**From:** [REDACTED]  
**Sent:** 14 June 2017 08:58  
**To:** Planning  
**Subject:** Planning application 6/2017/1079/FULL - 37 Lambs Close

District ref: 6/2017/1079/FULL  
HCC ref: WH/140/2017  
HCC received: 25/05/2017  
Area manager: Manjinder Sehmi  
Case officer: Anthony Collier

Location  
37 Lambs Close  
Cuffley  
EN6 4HD

Proposal  
The erection of 3x 2 bedroom flats

5 Proposed Site Plan - Roof Plan
1:200

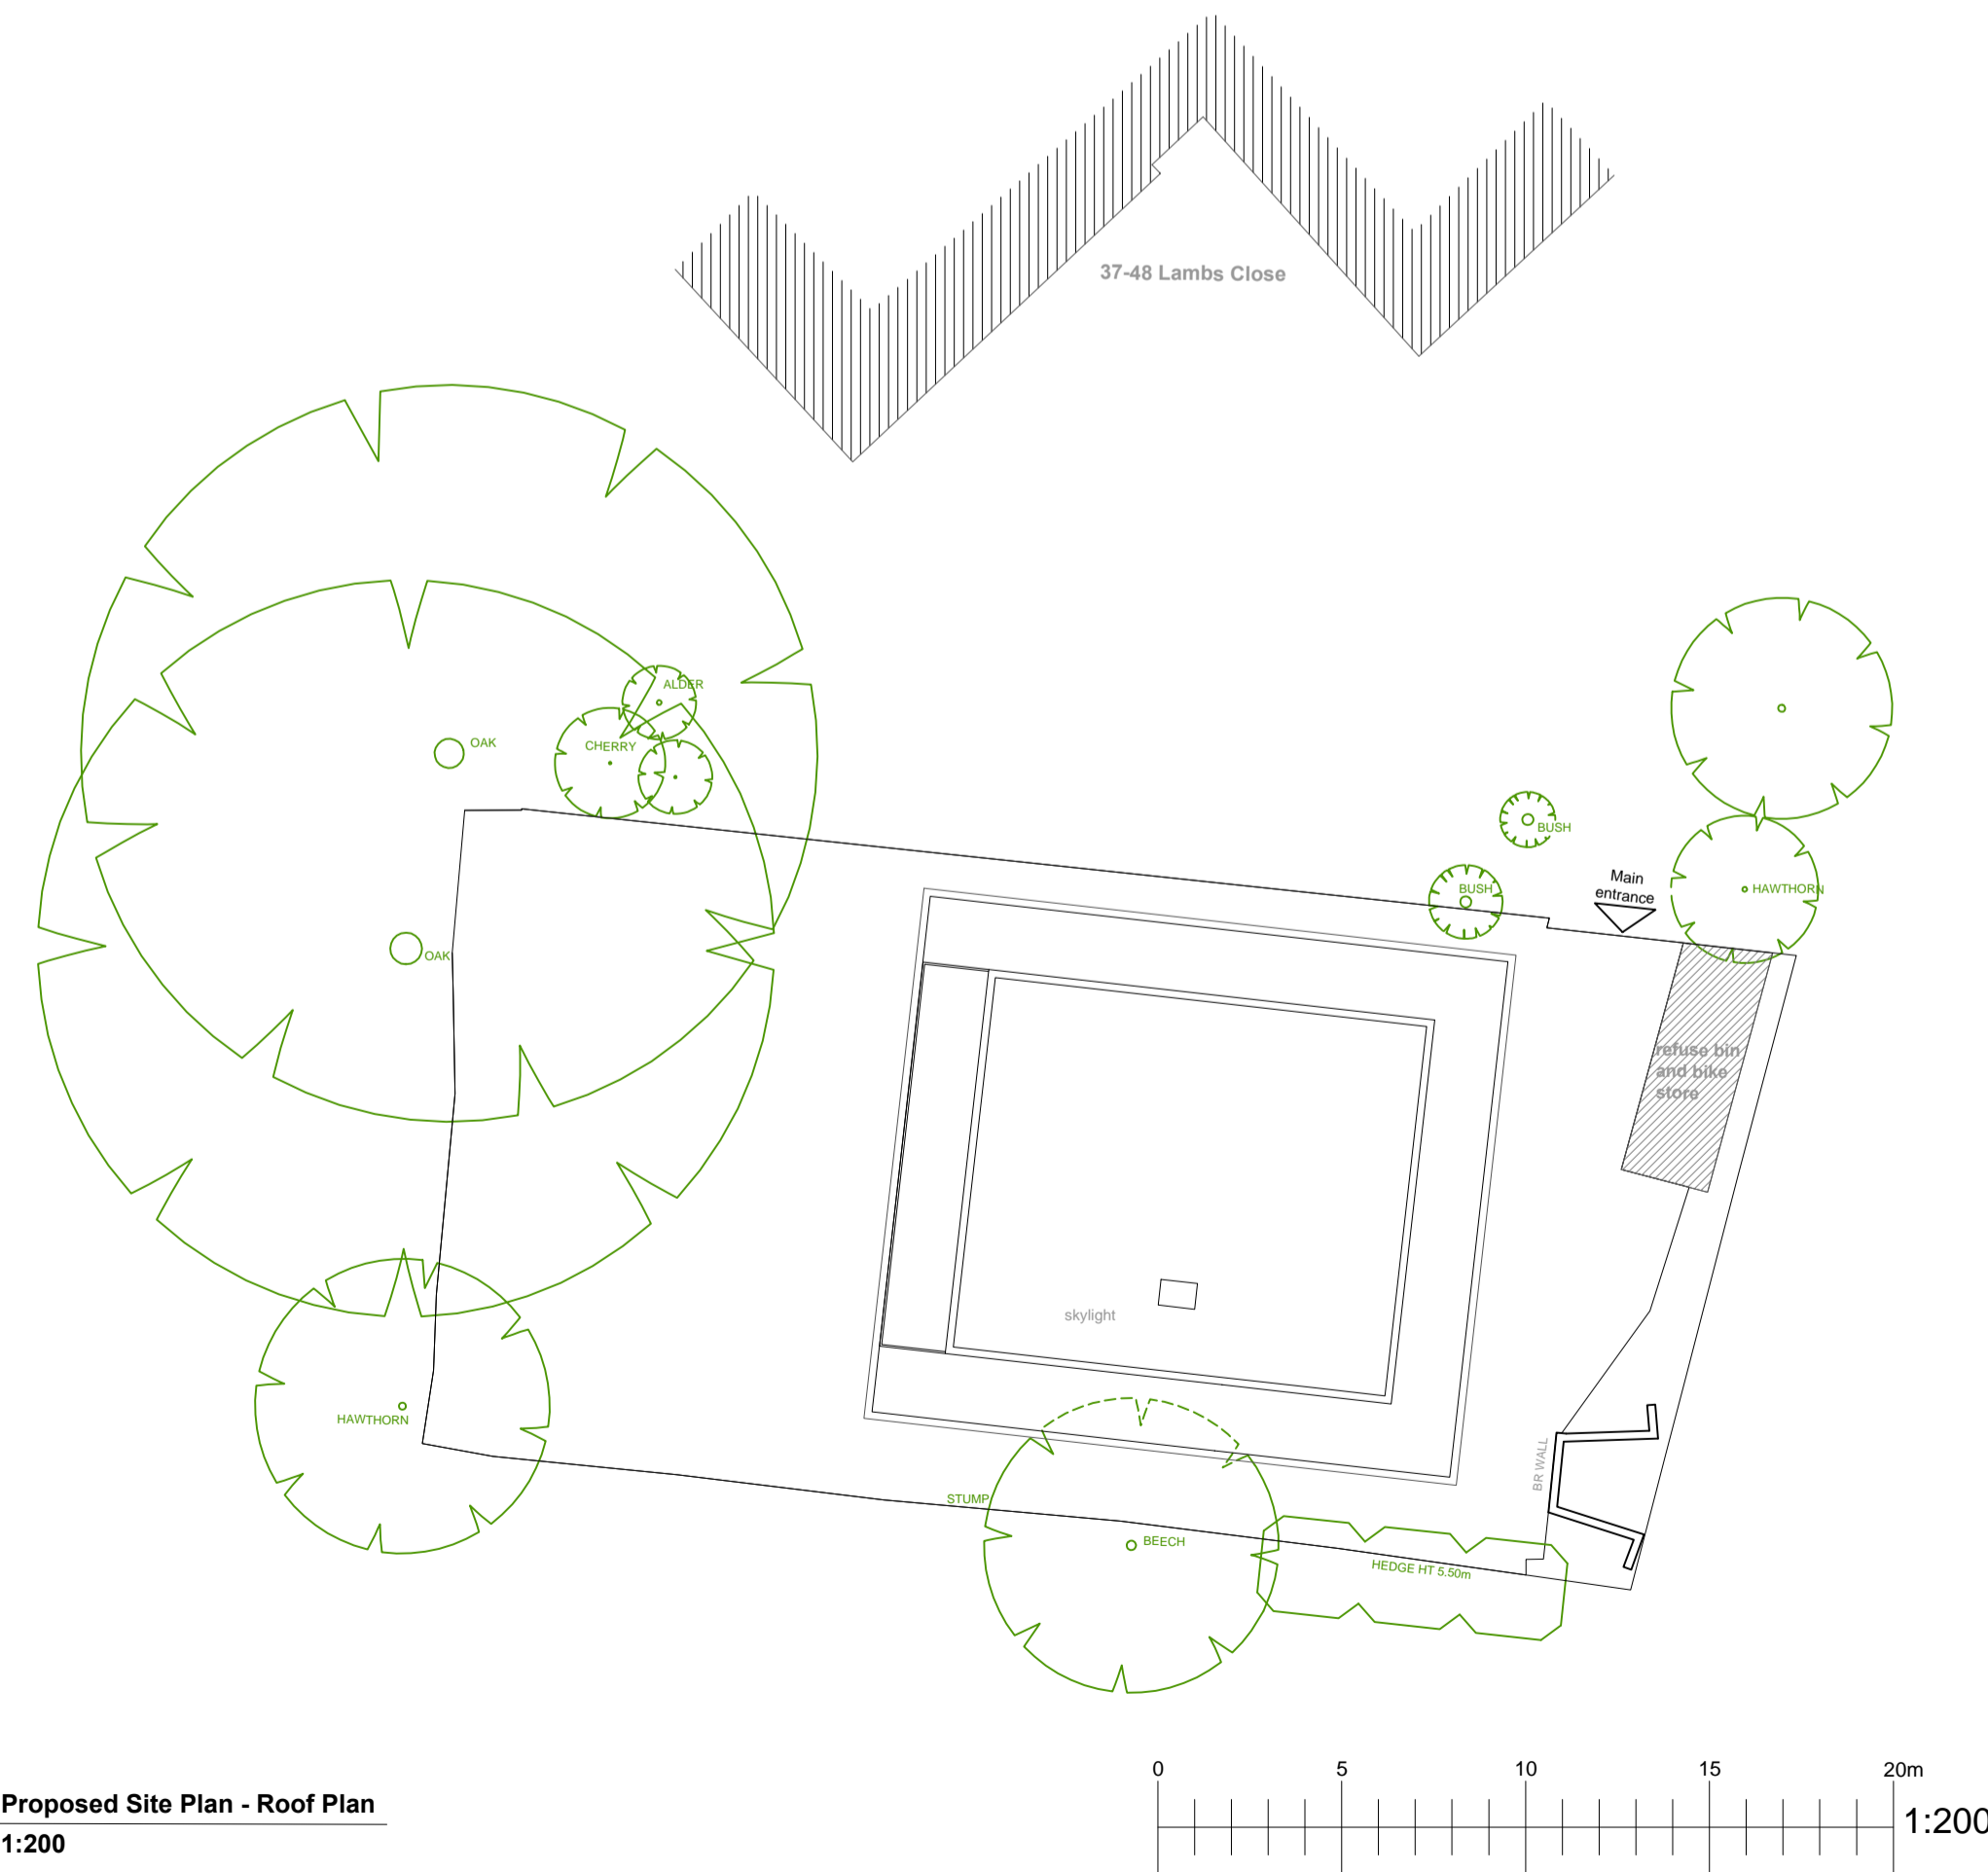
Parking layout provides an appropriate form of layout, all parking spaces are 2.4m x 4.8m in dimension, with a minimum of 6m clear space provided behind each space. Piers upon which the structure over shall be mounted do not appear to prejudice the use of any space. I would observe that the parking layout fails to consider the needs of disabled people, and the LPA may wish to review whether the parking provision should – for the development as a whole (including the flats for which it was originally provided) – include dedicated bays for persons with a disability. Access to the site is limited to existing width (4m) and insufficient to enable two way flow, however the access is set back from the extent of the public highway (Lambs Close, extent of highway maintainable at public expense is clearly delineated on site, but effectively to a point in line between the two blocks of flats known as 25 to 36 and 37 to 45 Lambs Close) and therefore I do not consider that the inability for vehicles to pass clear of other shall have significant implications on highway safety, particularly noting the low traffic speeds and volumes in this area.

The development provides bin stores and as noted in section 4.15, they location would be within safe carry distance, the LPAs waste management team may wish to confirm that sufficient capacity is provided, but I am satisfied that the bin stores are within an appropriate distance from point of collection and will have no material impact on existing servicing arrangements to the site.

The pedestrian access to the units provided ensures pedestrians are guided around the periphery of the car park,

Bin store doors would benefit from auto closing, or be hung such that their impact on vehicle flows be minimized at the access.
